From: Chantelle Bashford <Chantelle.Bashford@arun.gov.uk>
Sent: 10 January 2022 11:02
To: Planning.Responses <Planning.Responses@arun.gov.uk>
Subject: RE: Planning Consultation on: BR/267/21/PL

Application No: BR/267/21/PL

Site Address: Former Westside Supplies Unit West of 17 to 18 Durban Road Bognor Regis
PO22 9QT

Description of Works: Development of a new build four storey block of flats for 24 units (13 No 1 bed and 11 No 2 bed). This application is in CIL Zone 4 (Zero Rated) as flats.

FIRST + SECOND FLOOR PLAN

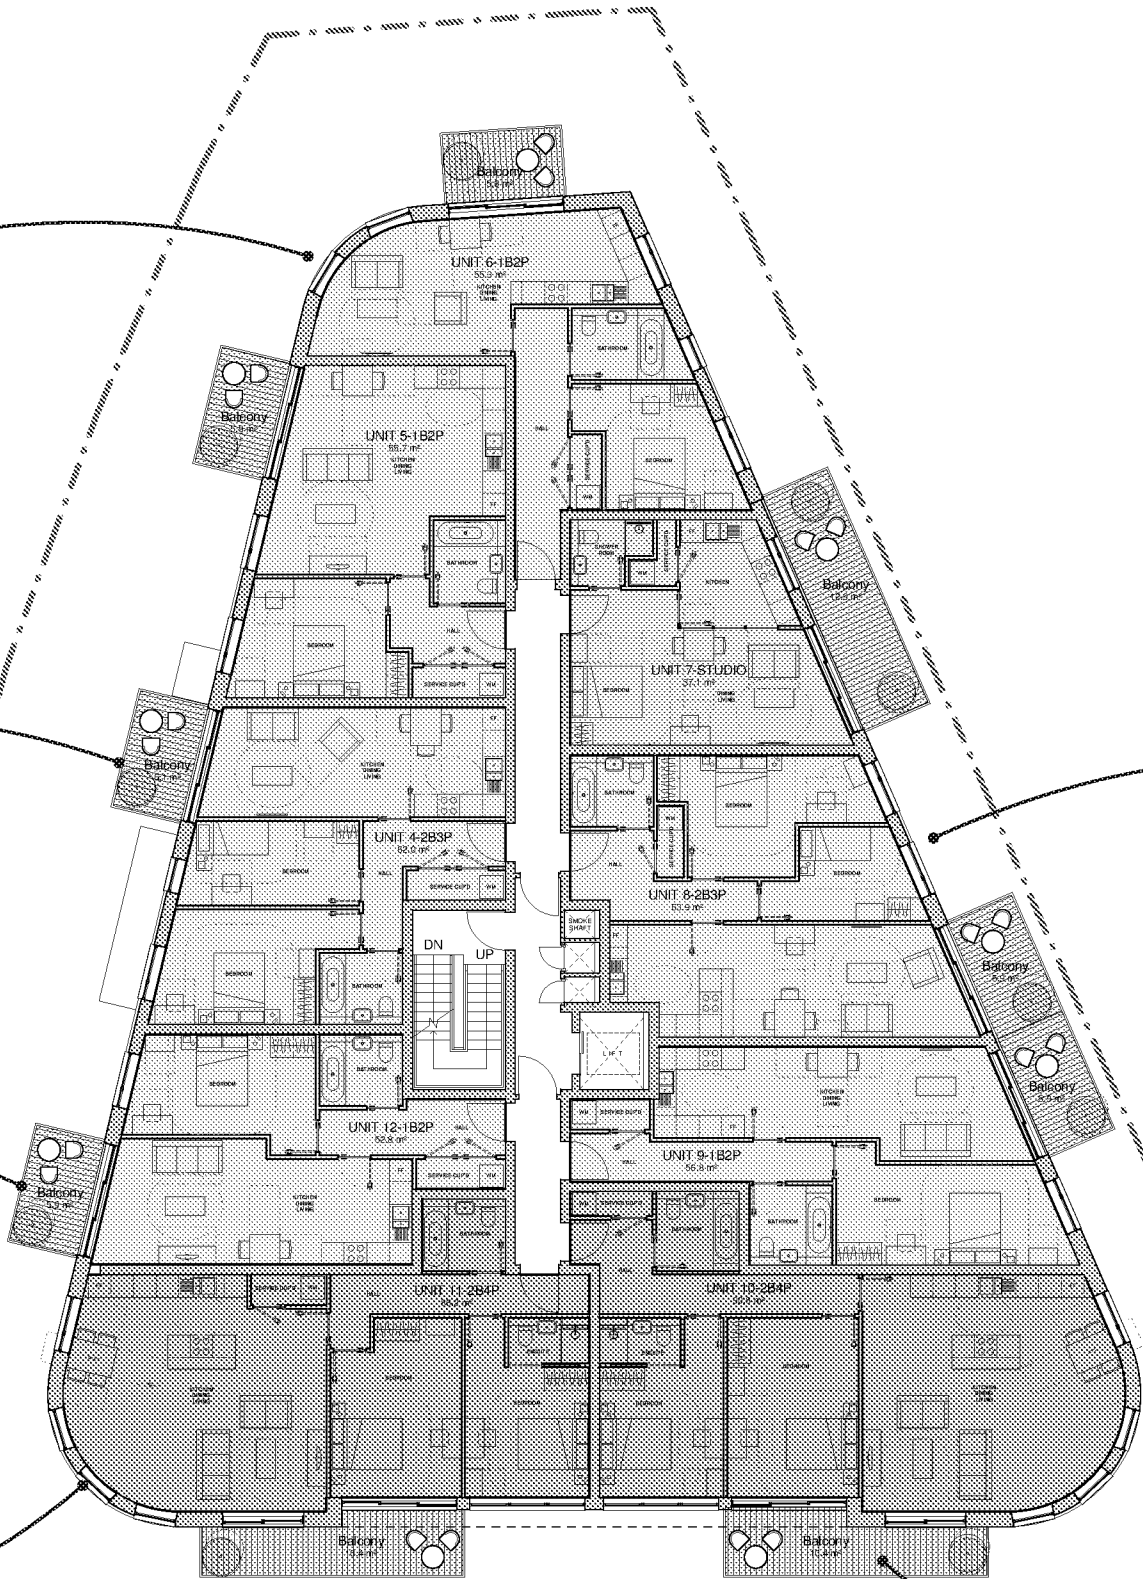
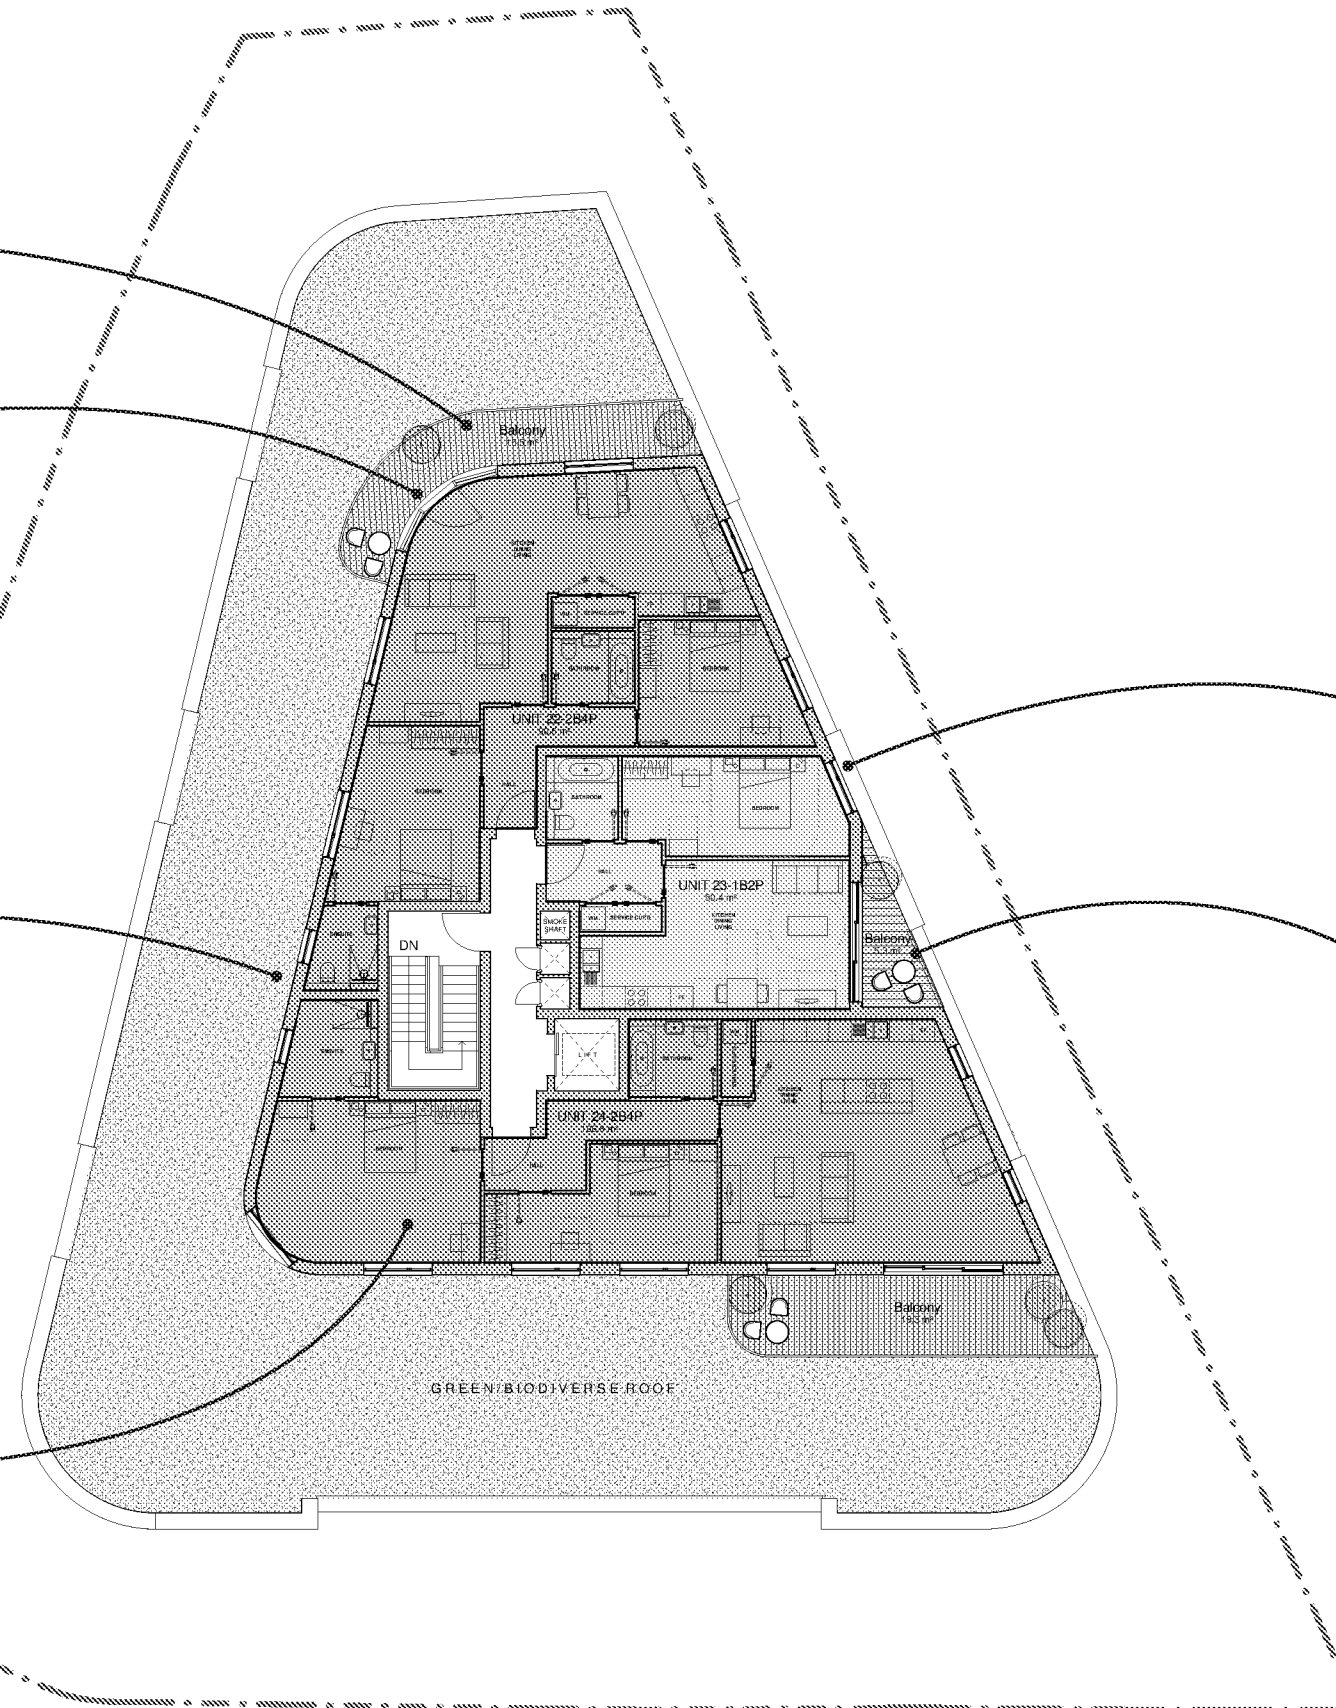
- Kitchens should have adequate mechanical ventilation
- Mechanical extraction should be provided to all bathrooms/shower rooms/ensuites
- Units 3, 7, 10, 11, 16, 19 & 20 appear to have a sliding door as the only means of ventilation within some of the bedrooms. Consideration should be given to installing a separate openable window light to the bedrooms in question to enable the ventilation to be better controlled. For example, enabling the occupier to have a window open during the night and during prolonged periods of rain. This is because an occupier is less likely to leave the balcony door open during the night for safety concerns and during heavy rain spells as rain water could enter the room

Typical Unit Example - 2B4P on upper floor with private balcony space.

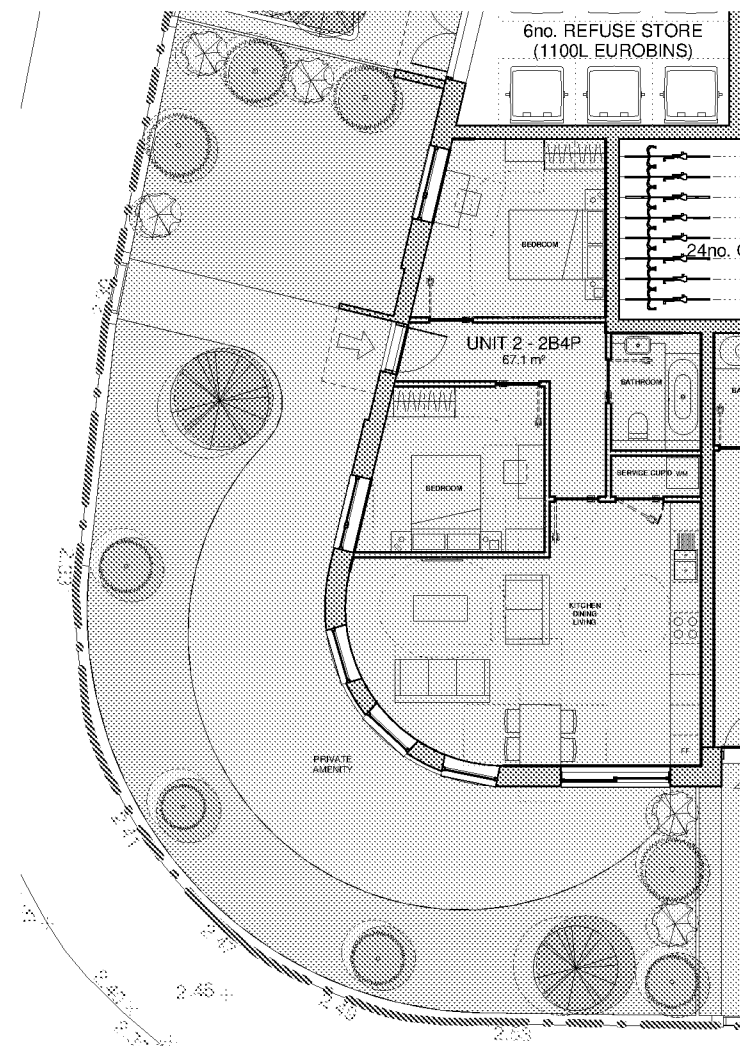
- Each terrace/balcony must provide a guarding height of 1100mm minimum, extending up from the terrace/balcony floor
- The openings within the guarding should not allow a sphere with a 100mm diameter to pass through
- The guarding should not be constructed so as to facilitate climbing by children
